1 Project details

Project:	Proposed Mosque and Madrasa, Healey Lane, Batley
Report title:	Stage 1 Road Safety Audit Response Report
Date:	07.10.2025
Document reference and revision:	21-382-007.02
Produced by:	Bryan G Hall
On behalf of:	Kirklees Council
Prepared by:	
Name:	Daniel McLean
Position:	Senior Transport Consultant
Signed:	
Organisation:	Bryan G Hall
Date:	
Checked By:	
Name:	Geoff Bowman
Position:	Consultant
Signed:	
Organisation:	Bryan G Hall
Date:	
Approved By:	
Name:	Nick Calder
Position:	Principal Engineer
Signed:	
Organisation:	Bryan G Hall
Date:

This is the Response Report for the Stage 1 Road Safety Audit (ref: 25-117-001.02) dated 05.08.2025 for a proposed mosque and madrasa on the existing Healey Lane site.

Drawing No: 21/382/ACC/001

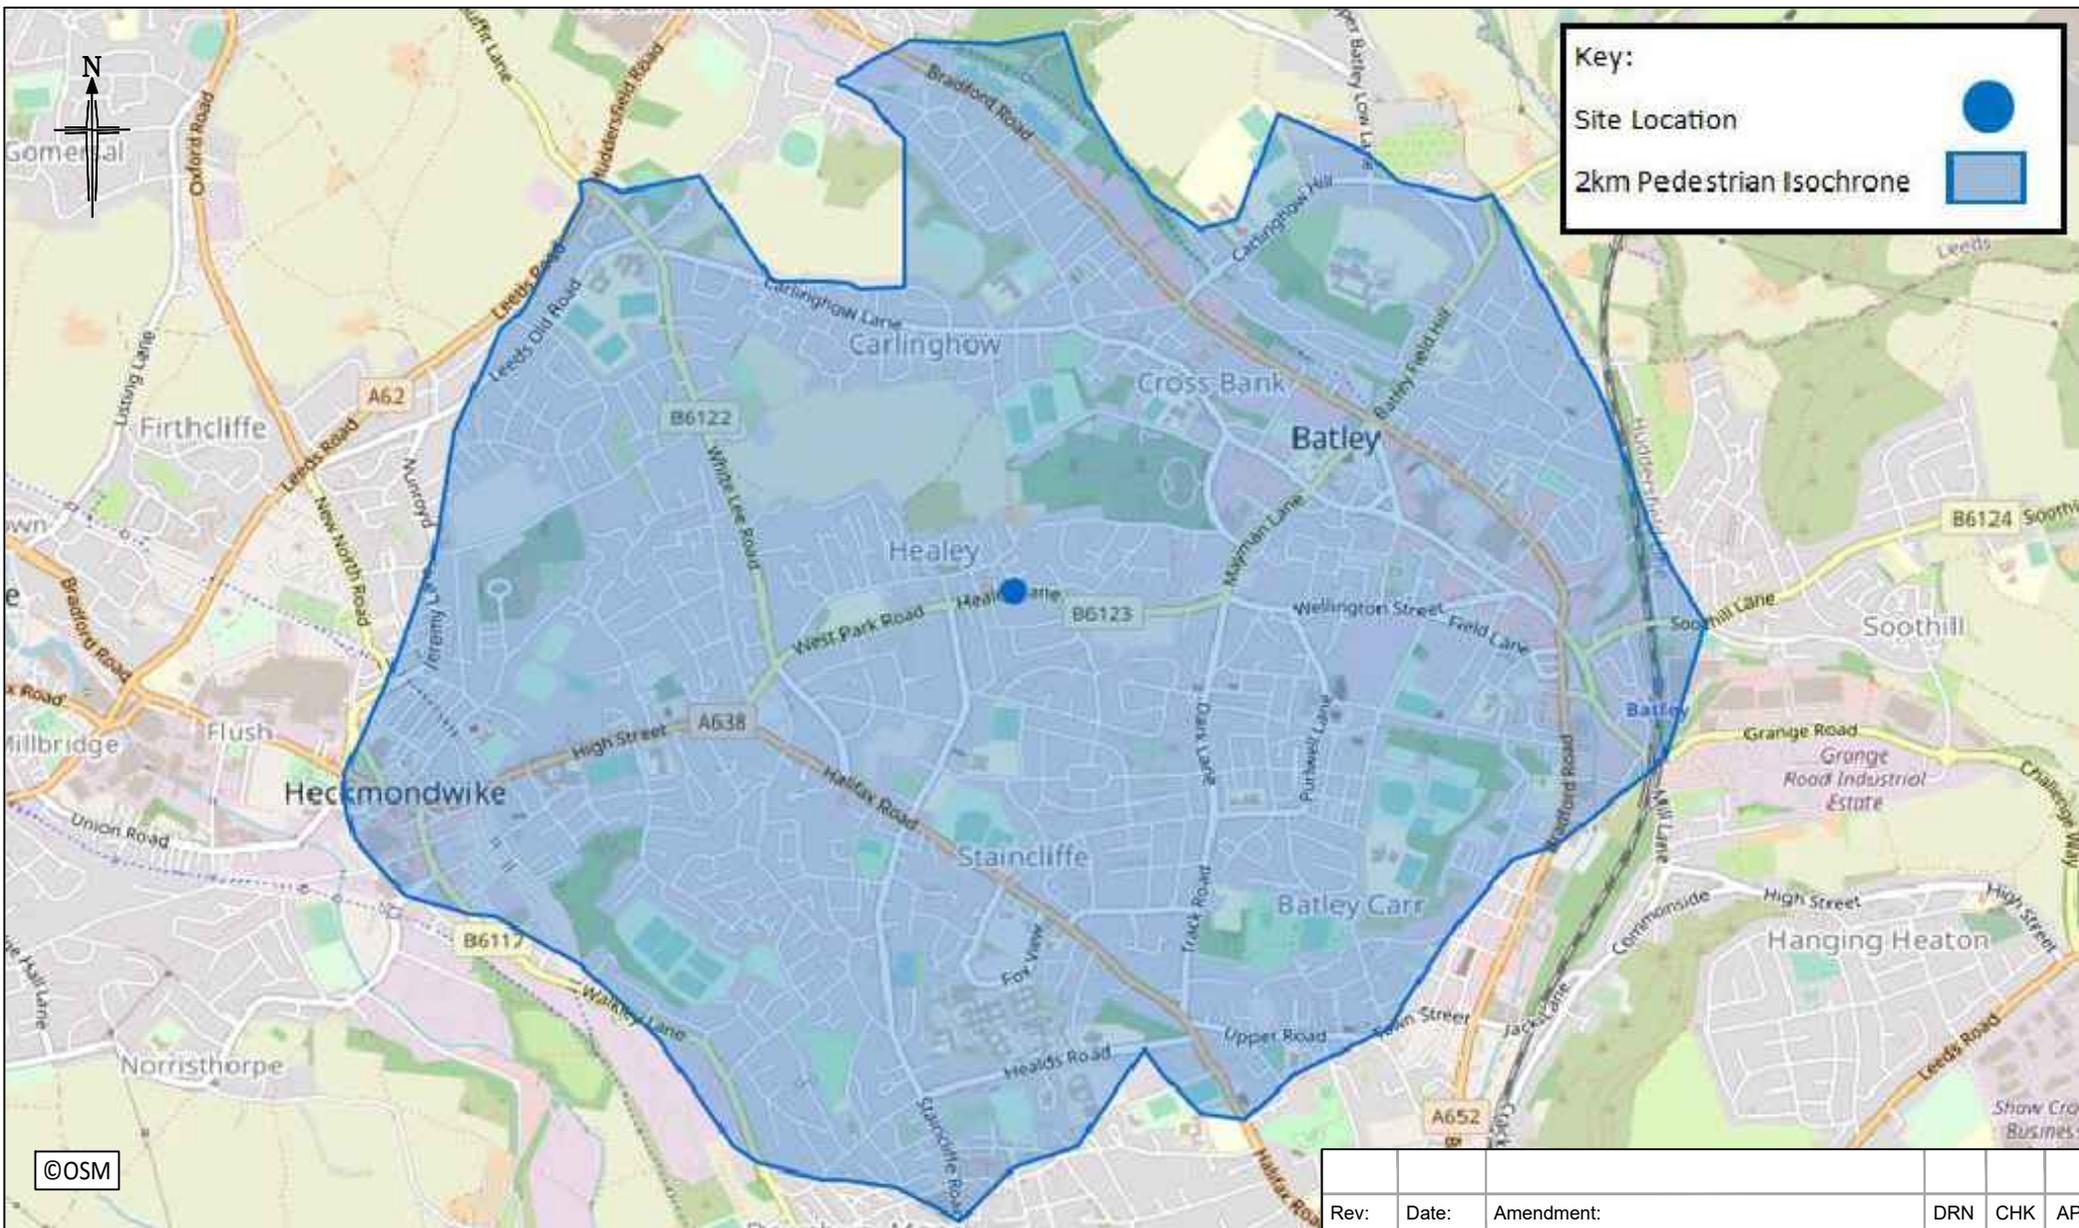
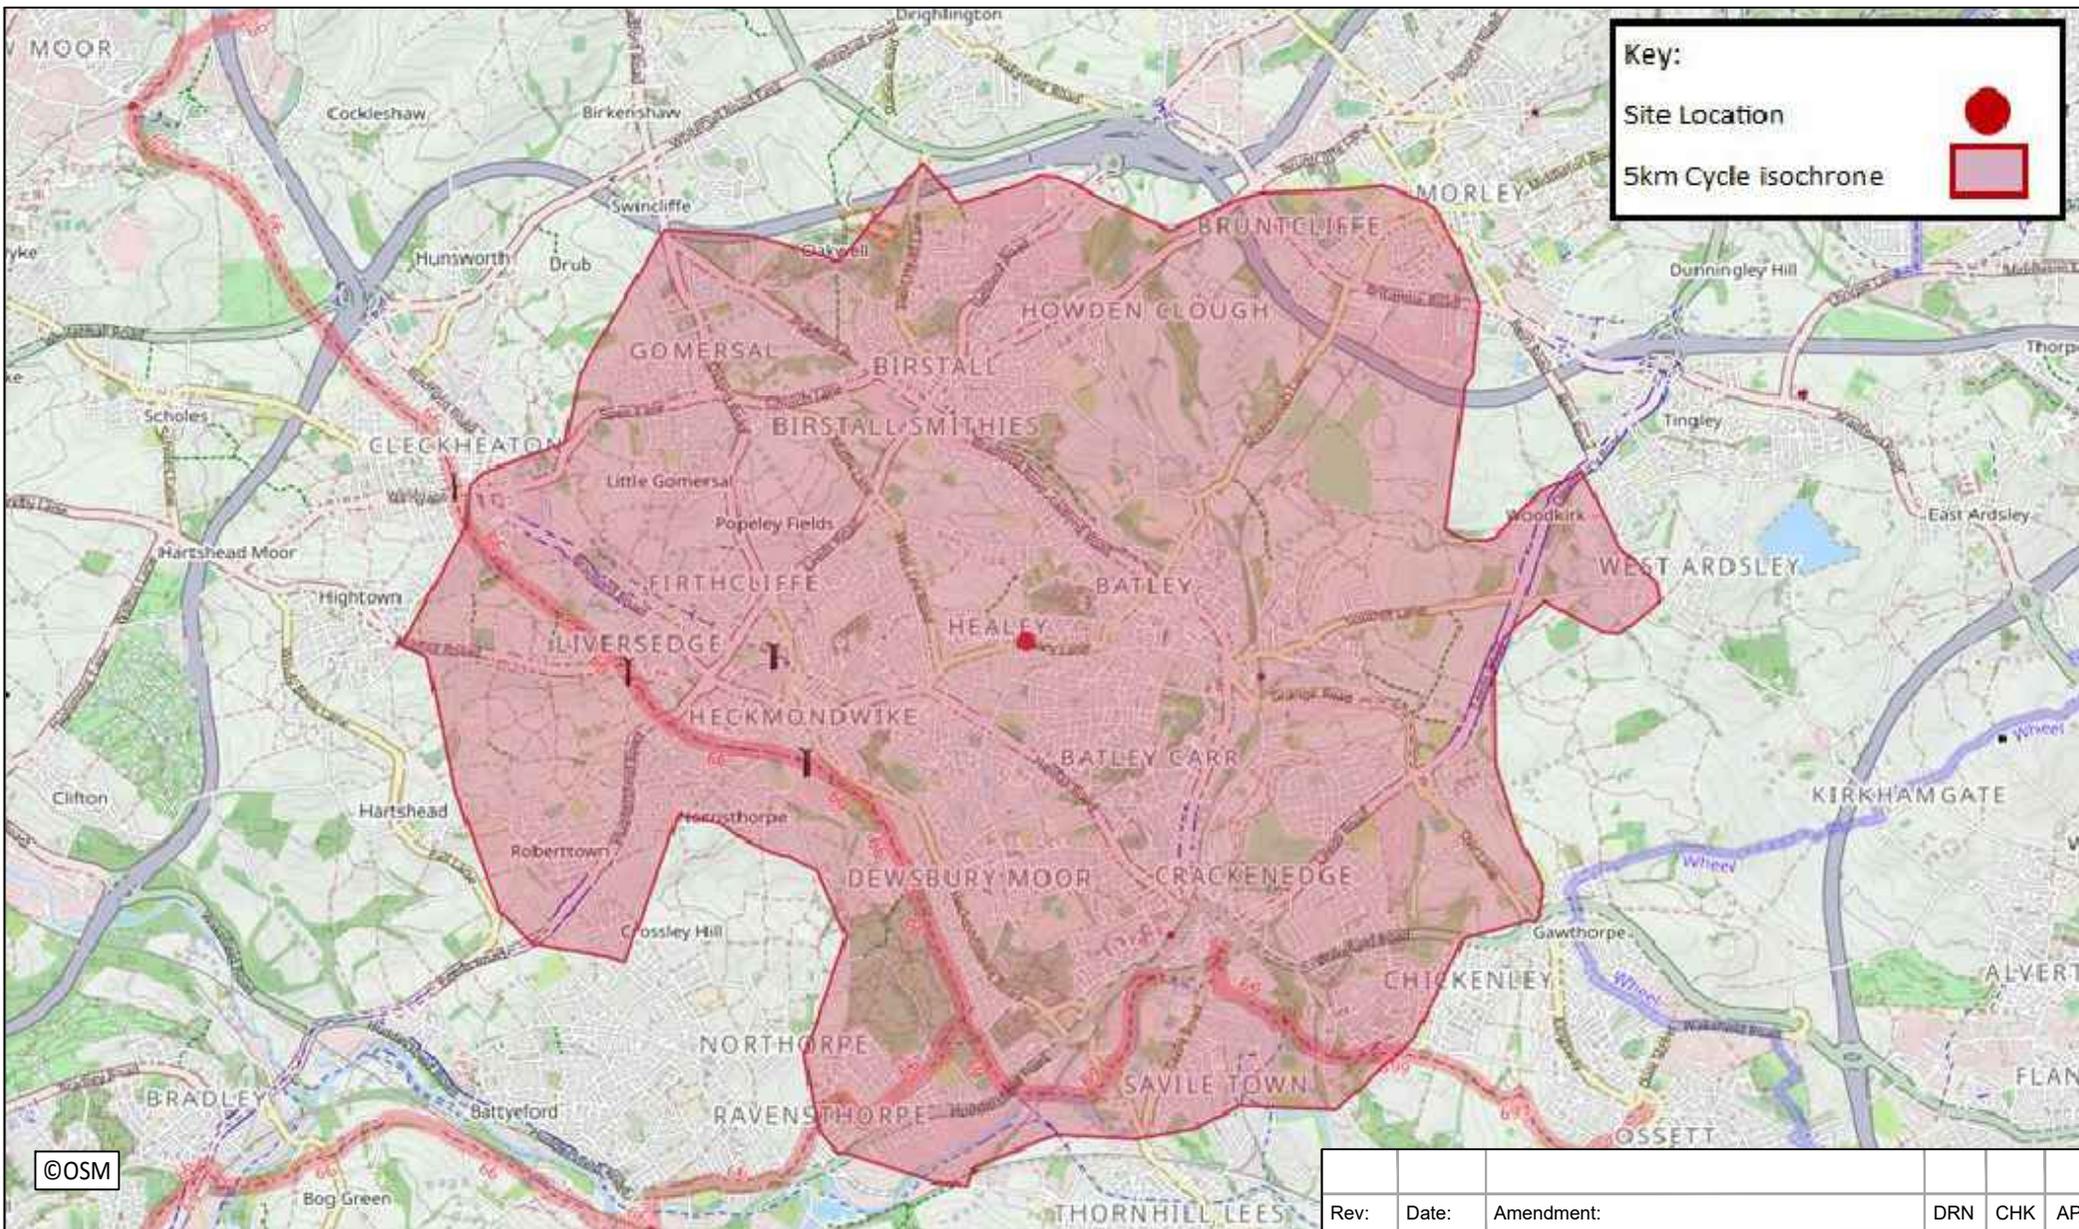
RSA Problem	RSA recommendation	Design organisation response	Overseeing Organisation response	Agreed RSA action
<p>A: Risk of collisions between vehicles waiting to turn right into the access from Healey Lane and vehicles travelling westbound.</p>	<p>Provide measures to ensure vehicles travelling westbound do not have to use the central hatching area when travelling around the bend or along the site frontage.</p> <p>Remove the on street disabled parking bays and implement 'no waiting at any time' restrictions on Healey Lane along the site frontage.</p>	<p>The updated site plan attached to this Response Report shows both on-street disabled bays are now to be removed. Four disabled bays will be provided within the site, which is an increase on the two currently being provided on Healey Lane.</p> <p>The updated site plan now also shows an extension of the recently implemented 'no waiting at any time' restrictions along the site frontage on Healey Lane.</p>	<p>Agree with RSA Recommendation and Design Team Response.</p>	<p>Appropriate changes to TROs to be carried out in conjunction with Kirklees Highway Safety Team and additional standard TRO charges (to be paid by the applicant) will apply.</p>
